Application by National Grid Carbon Limited for an Order Granted Development Consent for the Yorkshire and Humber Carbon Capture and Storage (CCS) Cross Country Pipeline

Joint Response by North Yorkshire County Council and Selby District Council to Second Round of Questions

Drax Pig Trap

**DRAX PIG TRAP  
PLANNING ARRANGEMENT**

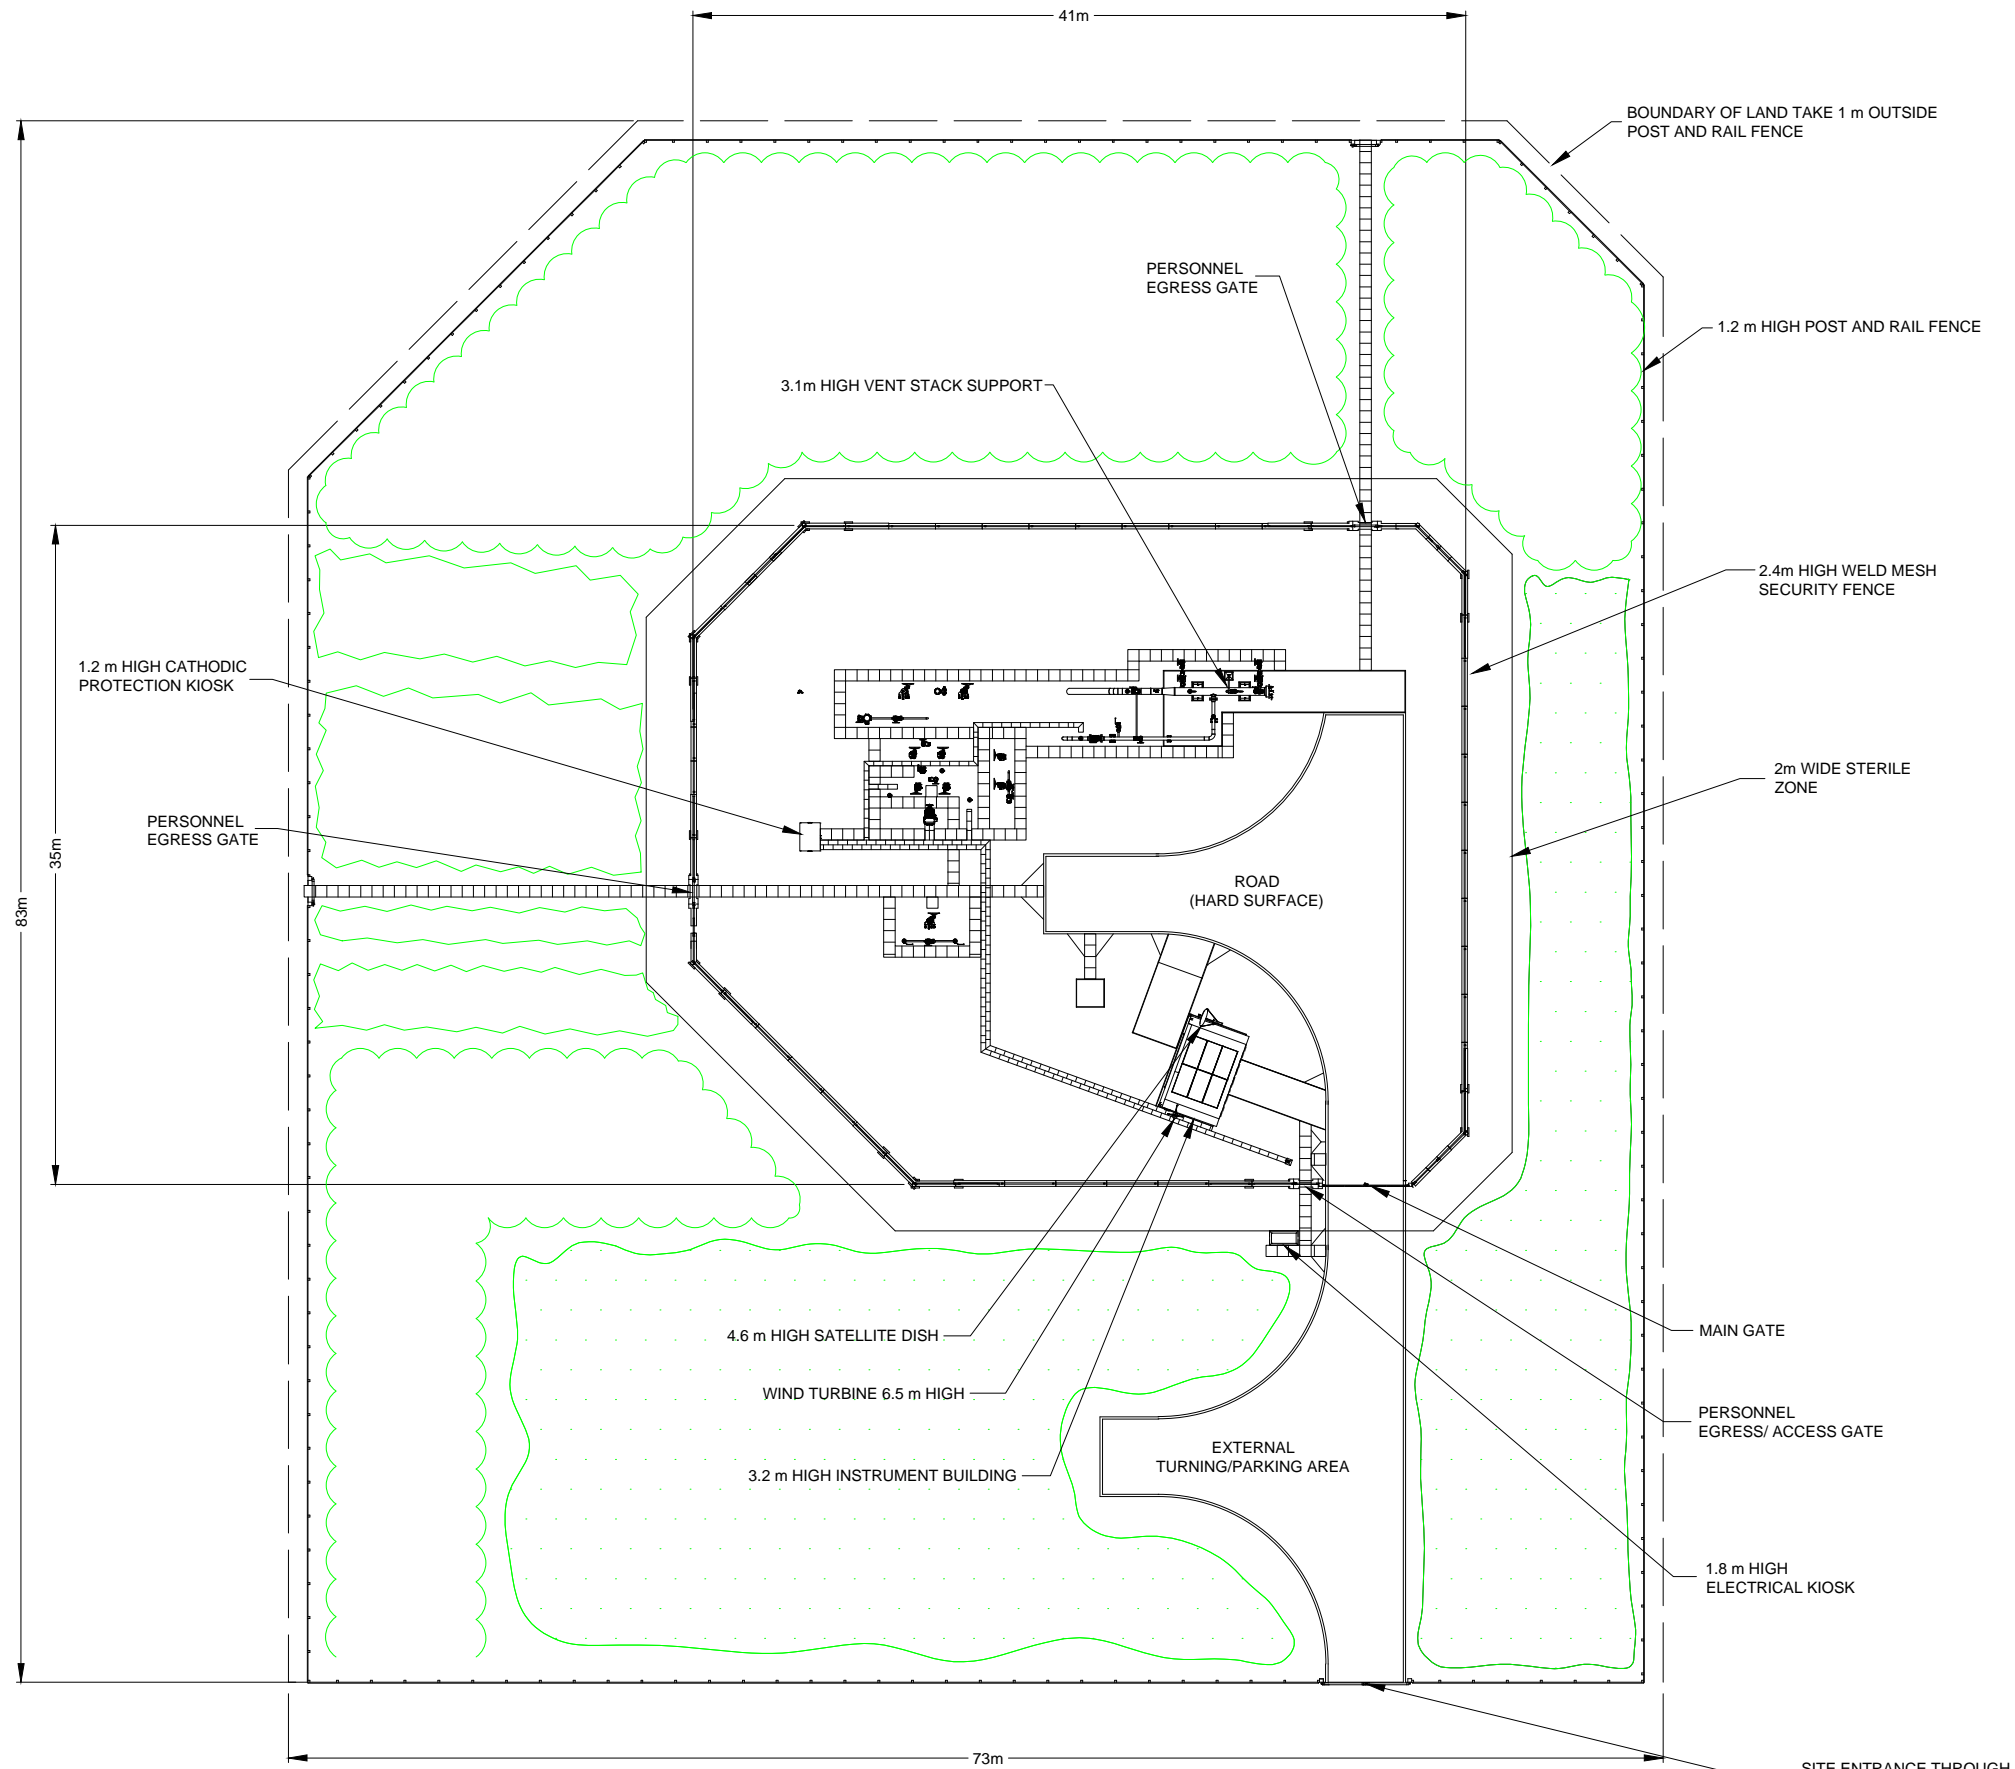
With regard to the Drax Pig Trap, the revised draft DCO received at deadline 4 and revised plans 2.18, 2.19, 2.20 and 2.22 also received at deadline 4 show an increase in the height of the security fence from 2.4m to 2.88m. This height appears to have been gained by the addition of three strands of barbed wire above the weld mesh security fence. These revised plans now reflect the fencing arrangements at other above ground installations (AGIs).

Please can the applicant confirm how this increase in height will impact upon the assessment of visual impact made in the Environmental Statement?

Please could Selby District Council comment on whether the additional 0.48m height of the security fence affects their assessment of the visual impact of the Drax Pig Trap?

North Yorkshire County Council (NYCC) provided the specialist Landscape and Visual input to the joint LIR with Selby District Council. Our position in relation to the Drax PIG Trap is as per the LIR. We still consider the PIG Trap to be more sensitive than the other AGIs because of its historic setting. Our expert is on leave and will comment on the specific impact of the higher security fencing and add to our response in relation to any additional adverse impact of the Drax PIG Trap by Wednesday.
